# CITY OF ALBUQUERQUE

**Re: Old Coors Fish Market**  
**809 Old Coors Blvd. SW**  
**30-Day Temporary Certificate of Occupancy**  
**Transportation Development Final Inspection**  
Architect's Stamp dated 05-13-22 (L11-D069)  
Certification dated 04-04-24

| SHEET NUMBER | AS-1.0 |

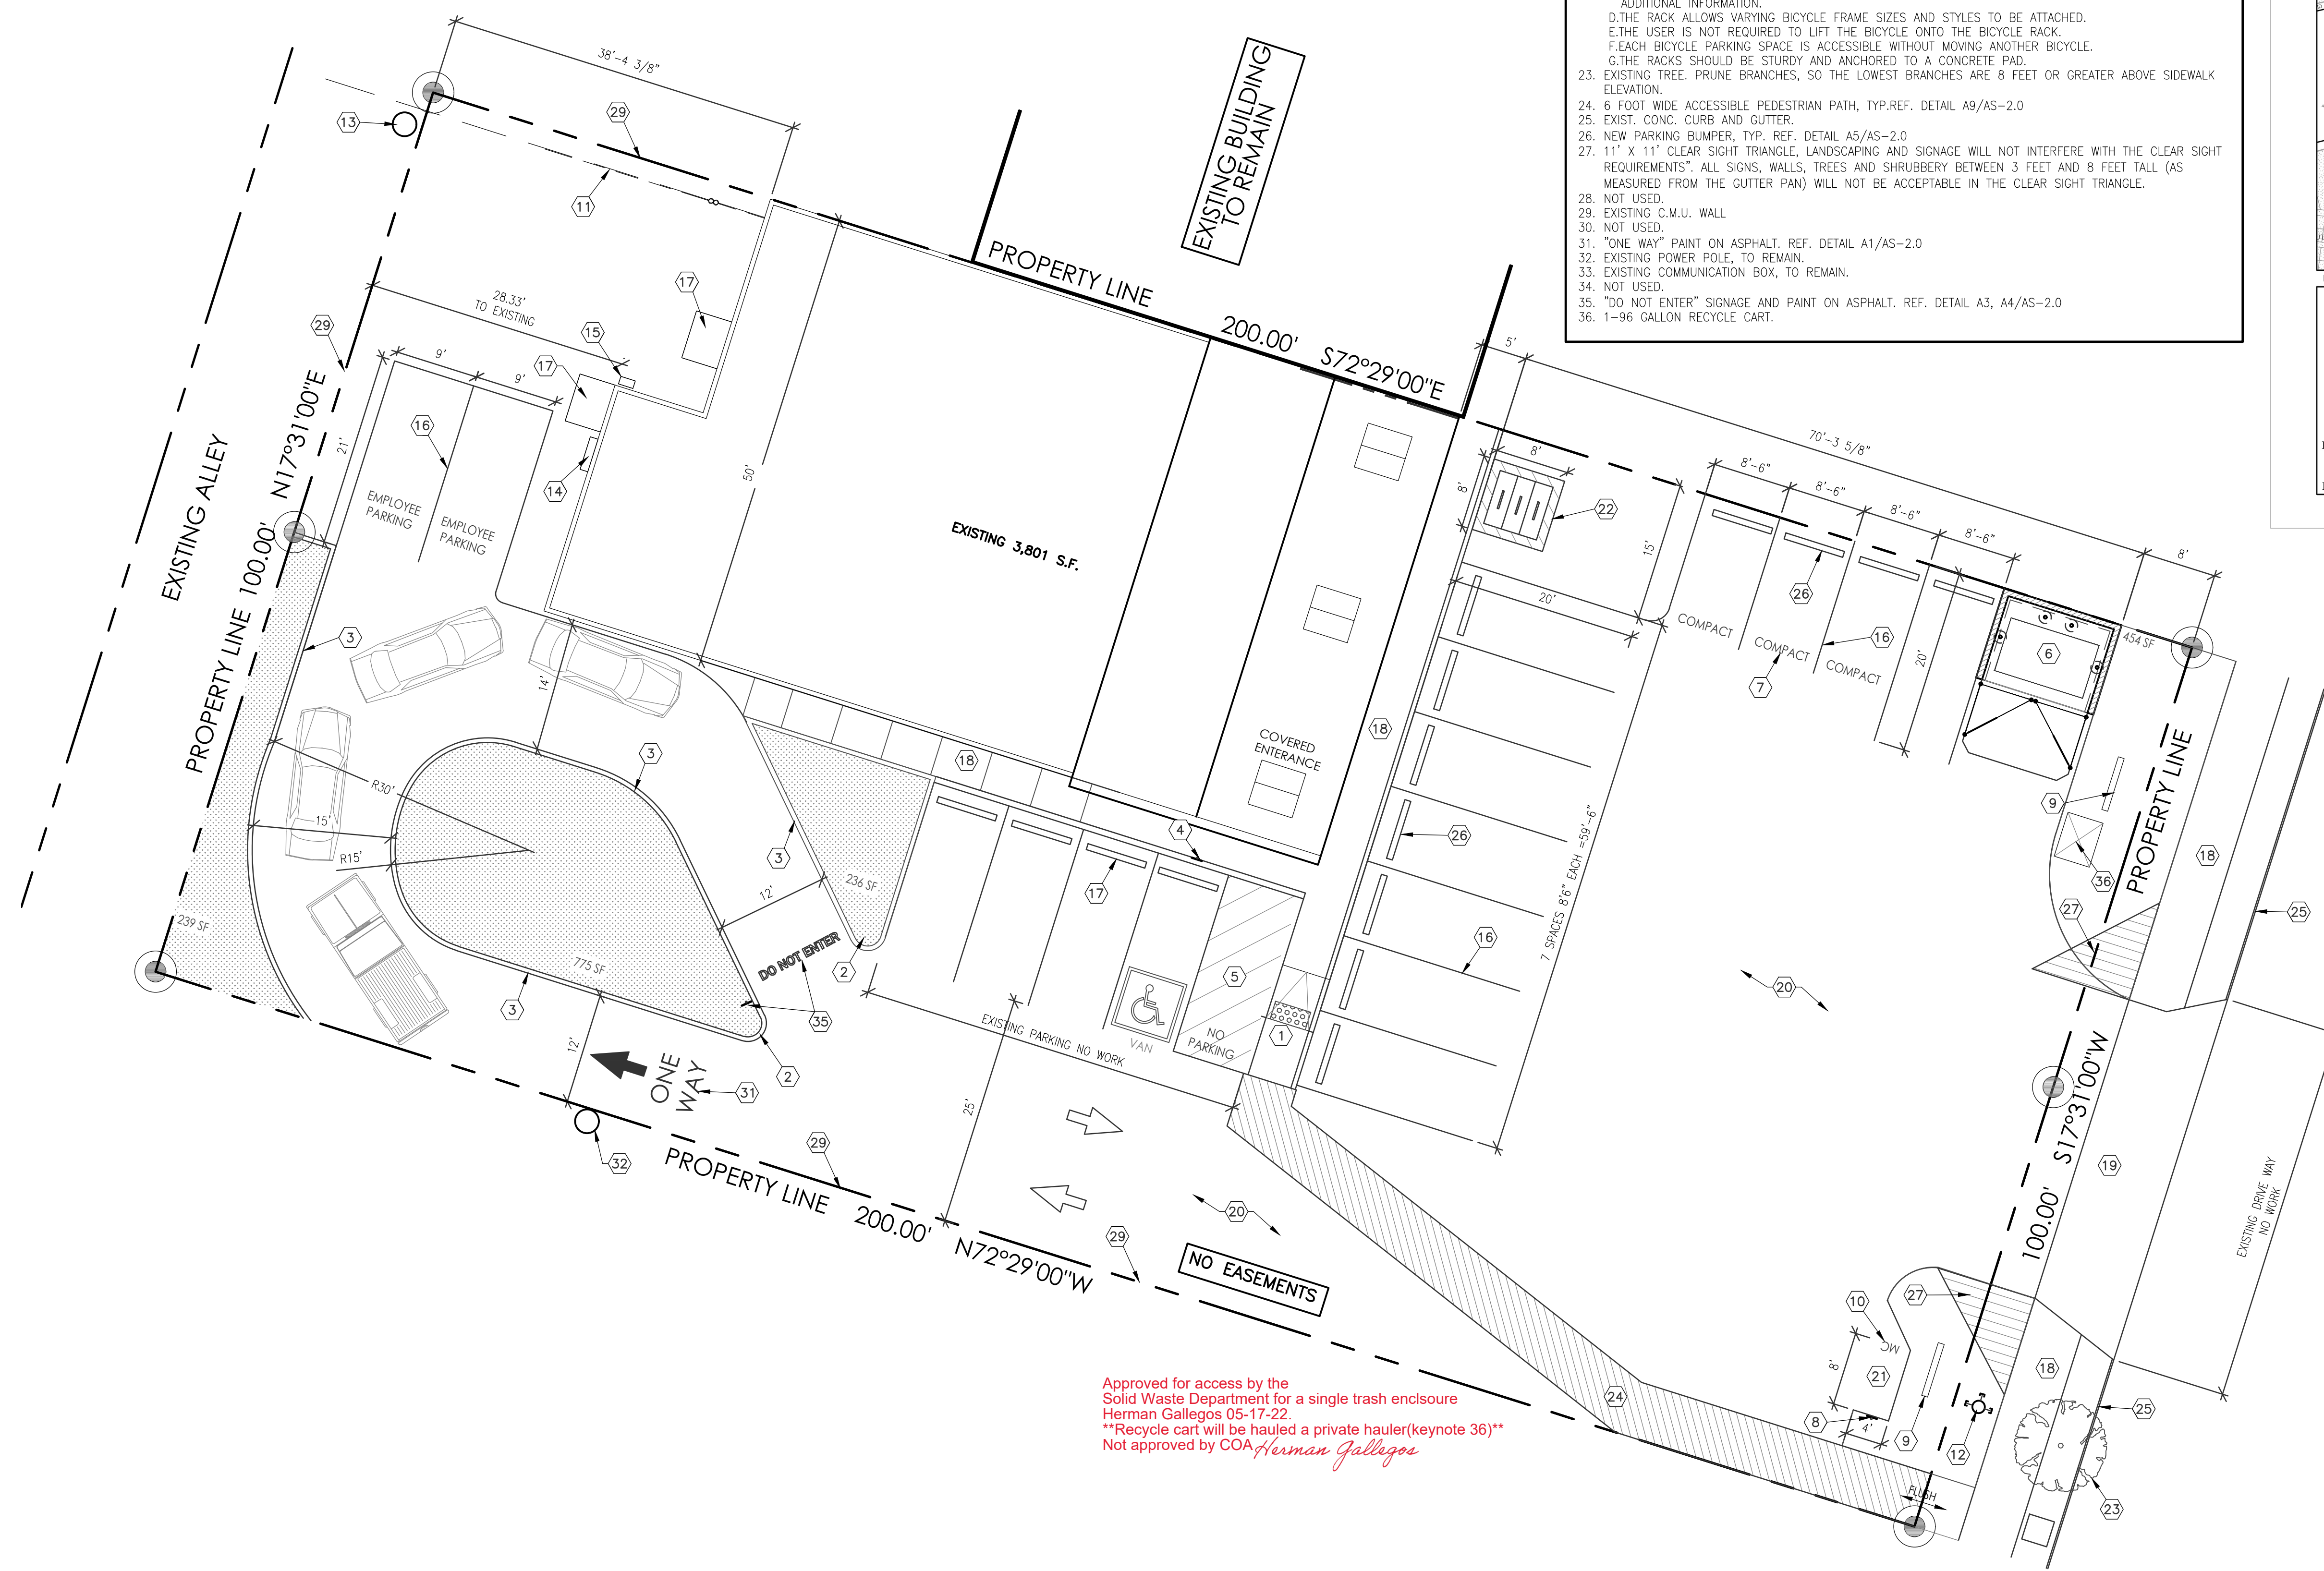
- The ADA accessible parking sign must have the required language per 66-7-352.4C NMSA 1978 **"Violators Are Subject to a Fine and/or Towing."** Please call out detail and location of signs.
